From: Martyn White
Sent: 19 October 2018 15:26
To: Planning.Responses
Subject: Y/75/18/L

Y/75/18/L

The application is for the conversion of an existing outbuilding to ancillary accommodation to main dwelling.

PROPOSED FRONT ELEVATION AT 1:100 SCALE
NORTH EAST

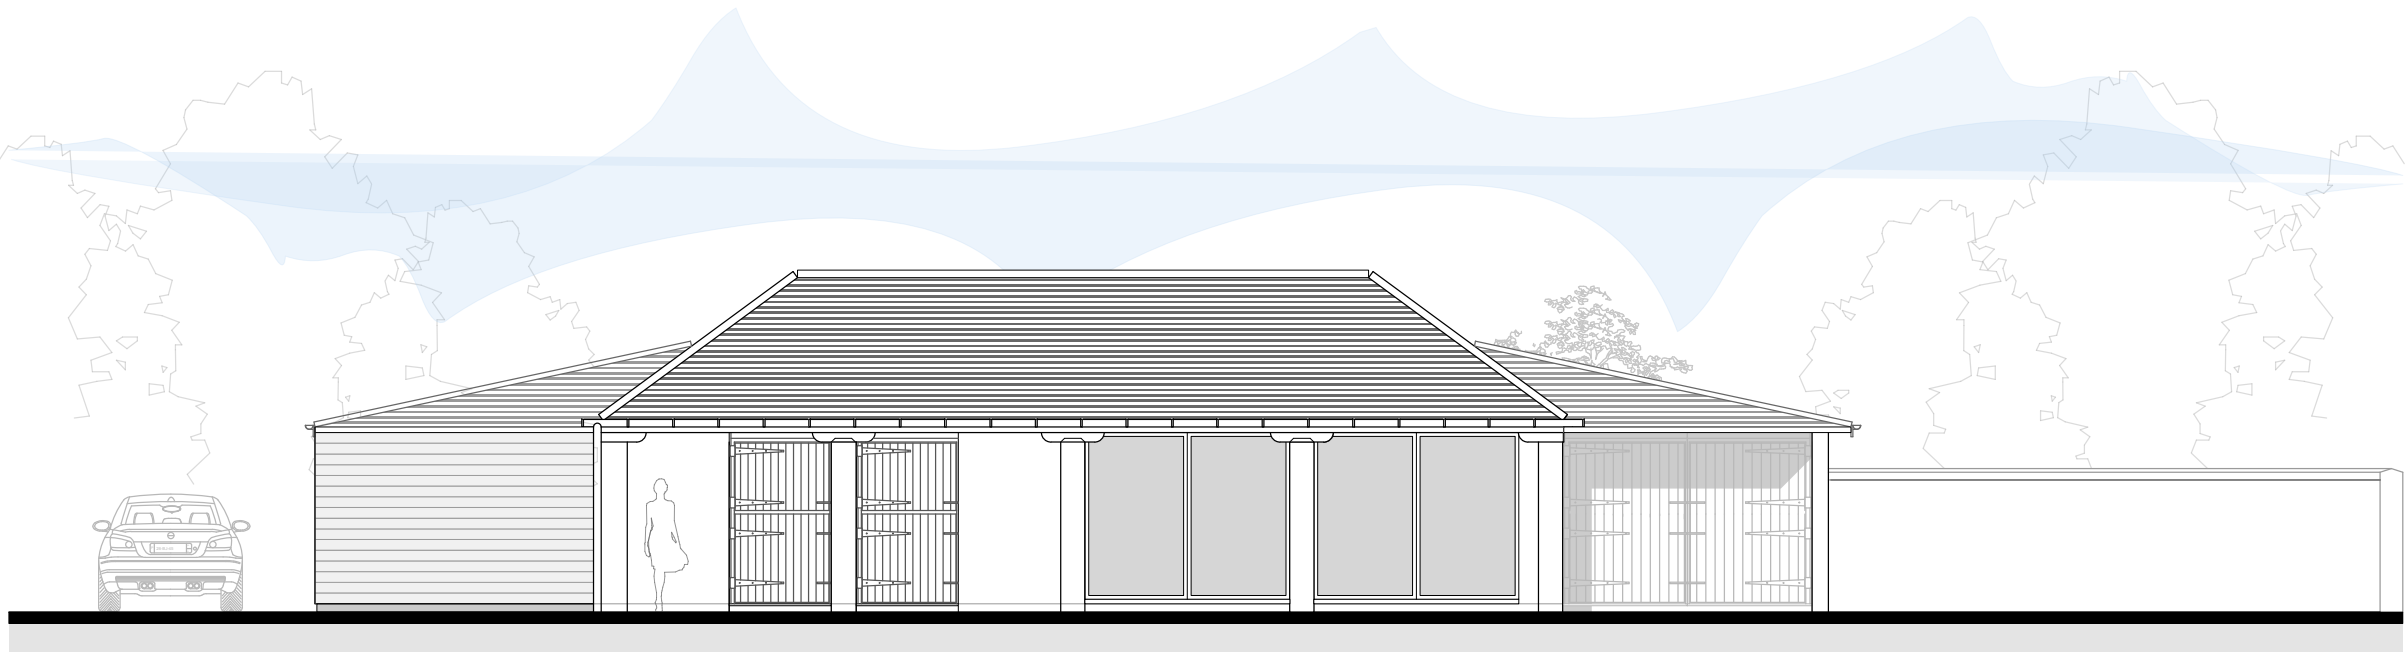
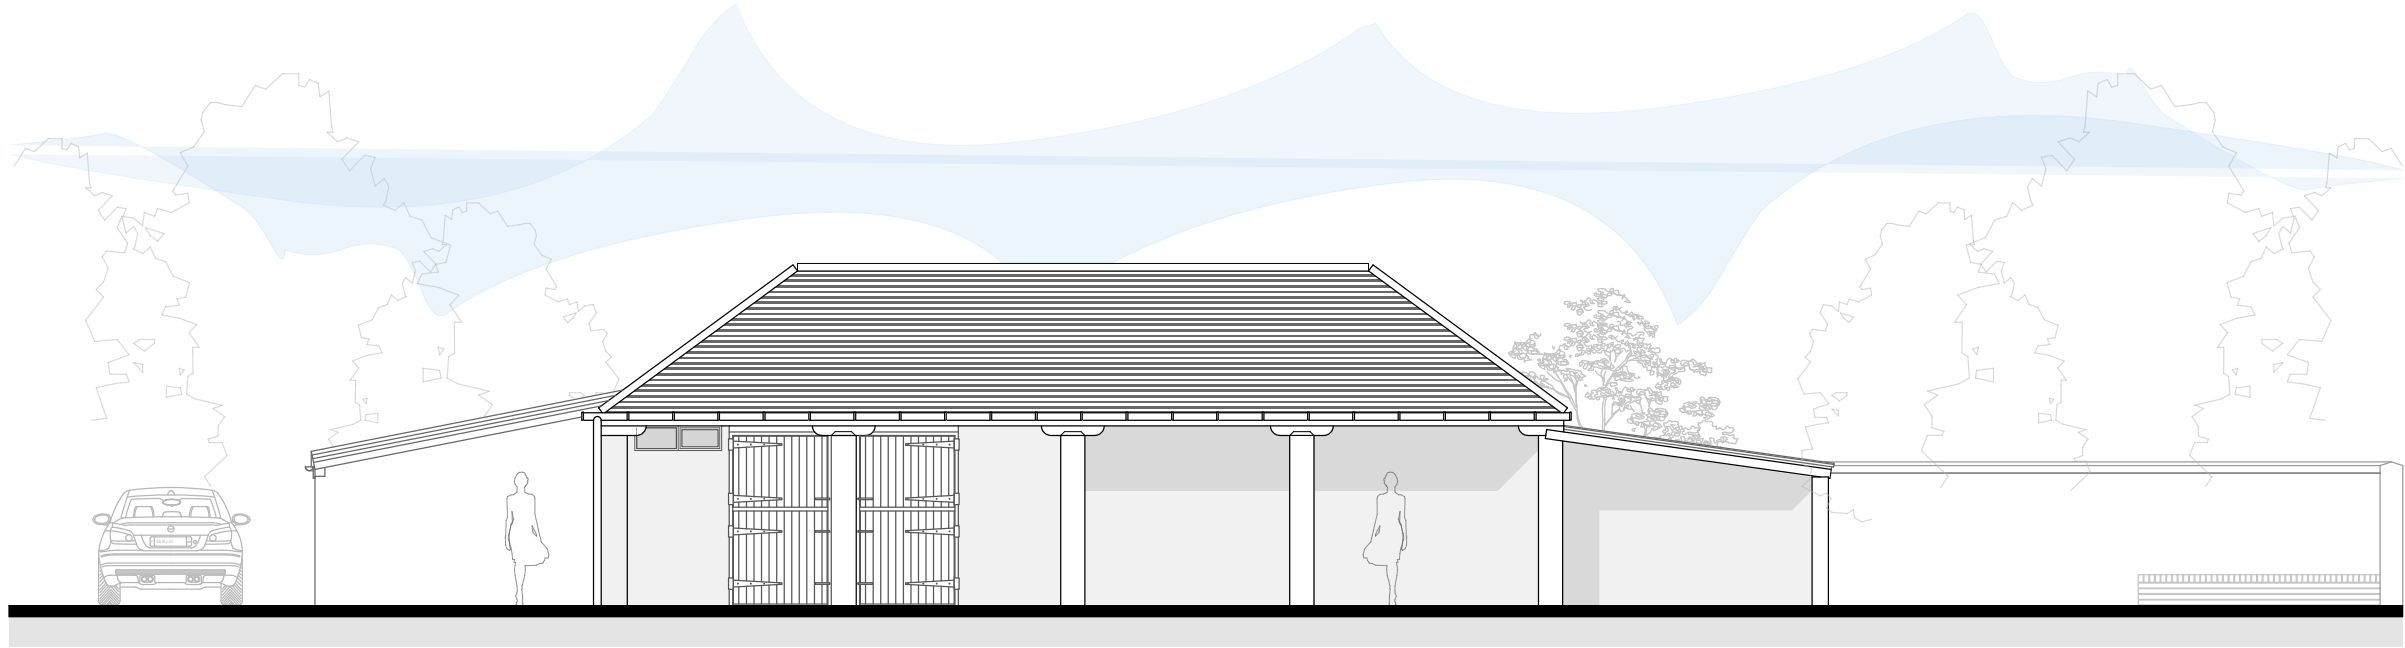
The use of aluminium windows are considered acceptable as they can actually be more discrete than solid wooden ones, subject to the details of the windows/doors – the frames should be minimal and discrete. This approach is supported by the relevant Historic England Guidance.

I note that the proposal is to maintain two existing timber doors as an attempt to reduce the impact of the glazing. Such an approach maintains the traditional appearance of the structure, and can be supported.

However, the glazing in all of the existing openings (doors and cart) should also be set deep in the reveal of existing openings. This creates shadow lines and minimises reflections and impact upon the character of the building.
